Project Title: Hawthorne Elementary School North Parking Lot Reconstruction Building Permit #: _____ City Drainage #: K20 D013A

**RE: Hawthorne Elementary School
Parking Lot Improvements
Grading and Drainage Plan
Engineer's Stamp Date 4-27-2016 (File:K20D013A)**

DRAINAGE PLAN AND CALCULATIONS NORTH PARKING LOT RECONSTRUCTION HAWTHORNE ELEMENTARY SCHOOL

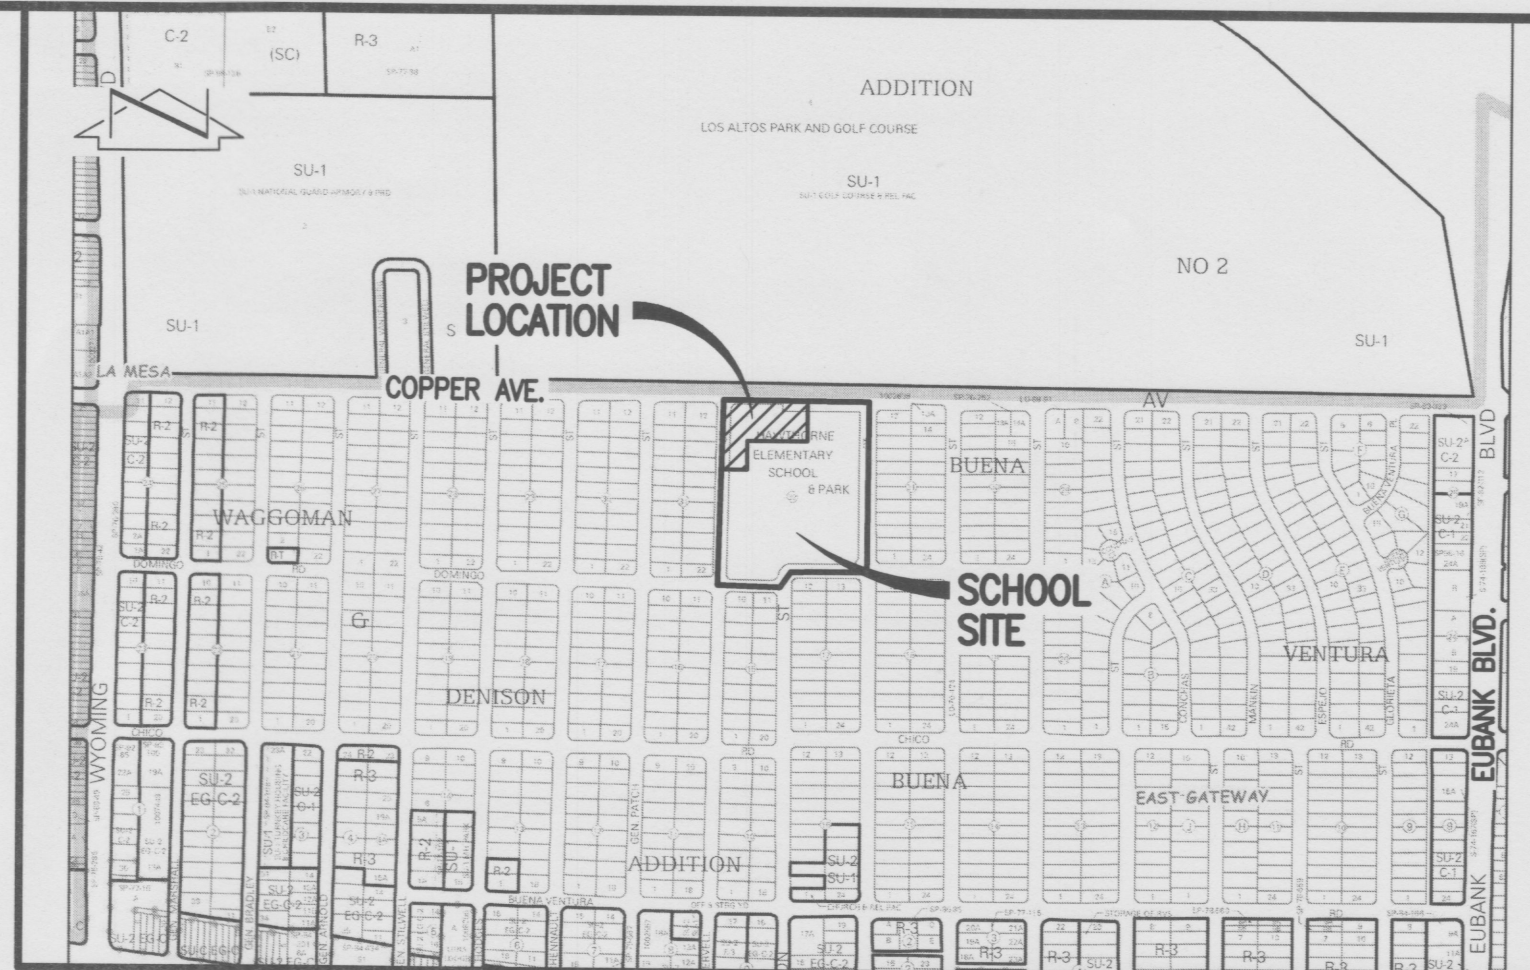
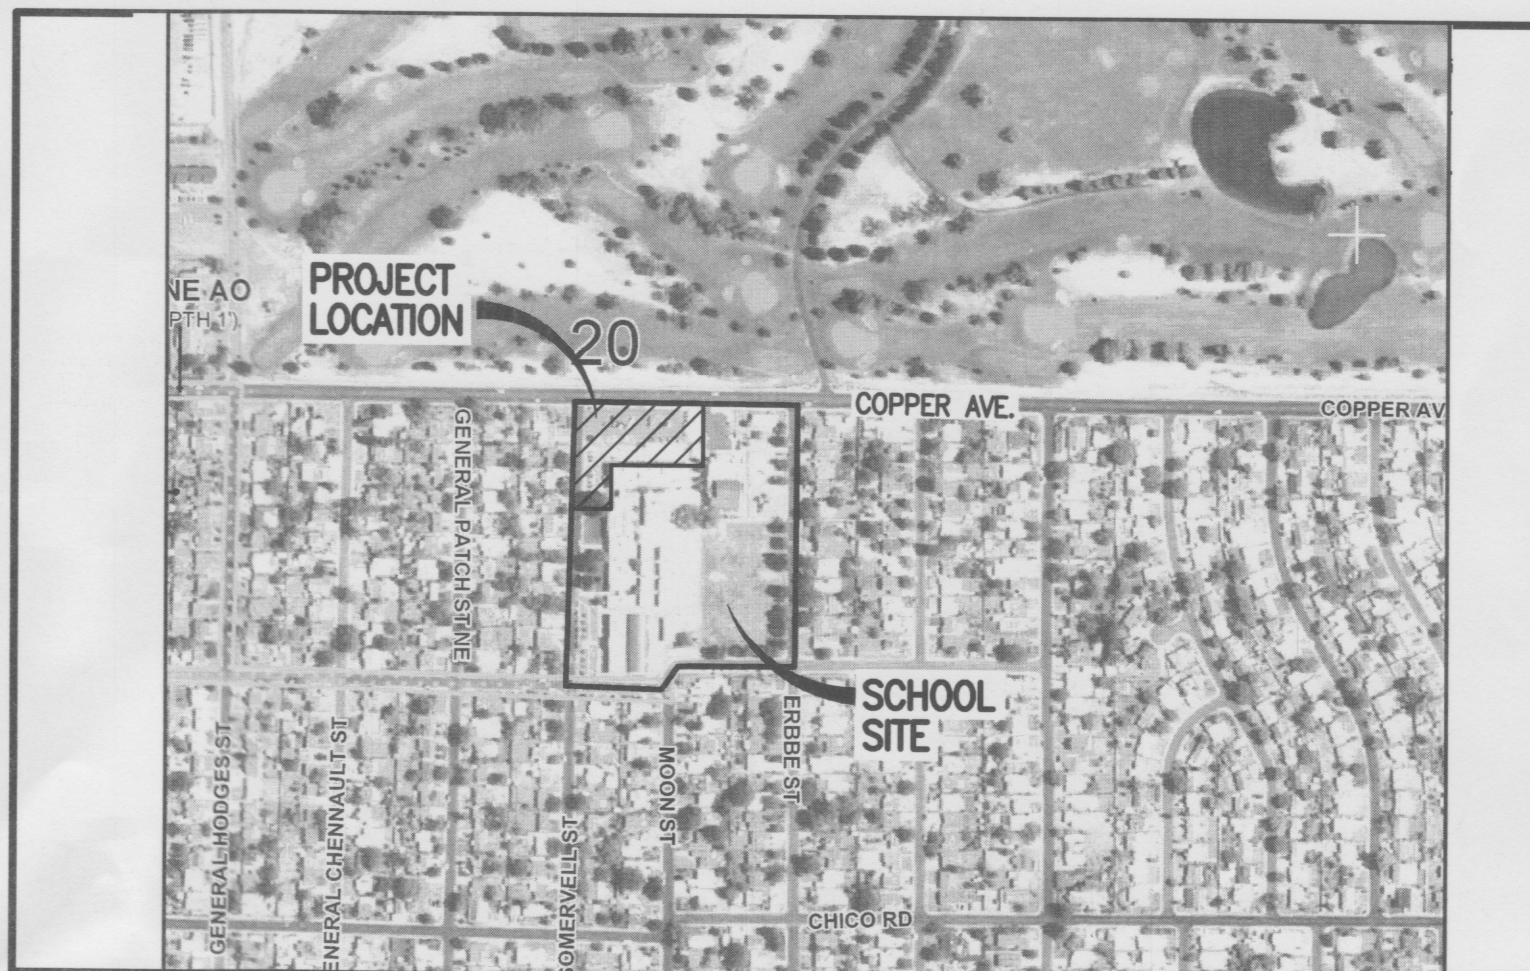
Based upon the information provided in your submittal received 4-8-2016, the above referenced Grading and Drainage Plan is approved for Grading Permit and Paving Permit with the condition that the north-westernmost first flush pond includes a sidewalk culvert spillway onto Copper Ave or General Somervell Street. The culvert cannot conflict with the ADA ramp.

Please ensure that the SO-19 Notes and the City's Sidewalk Culvert Standard Drawings are in the Construction Documents for the Contractor to adhere to. If there is a question regarding the planning of the culvert, the Contractor can contact Jason Rodriguez, 235-8016.
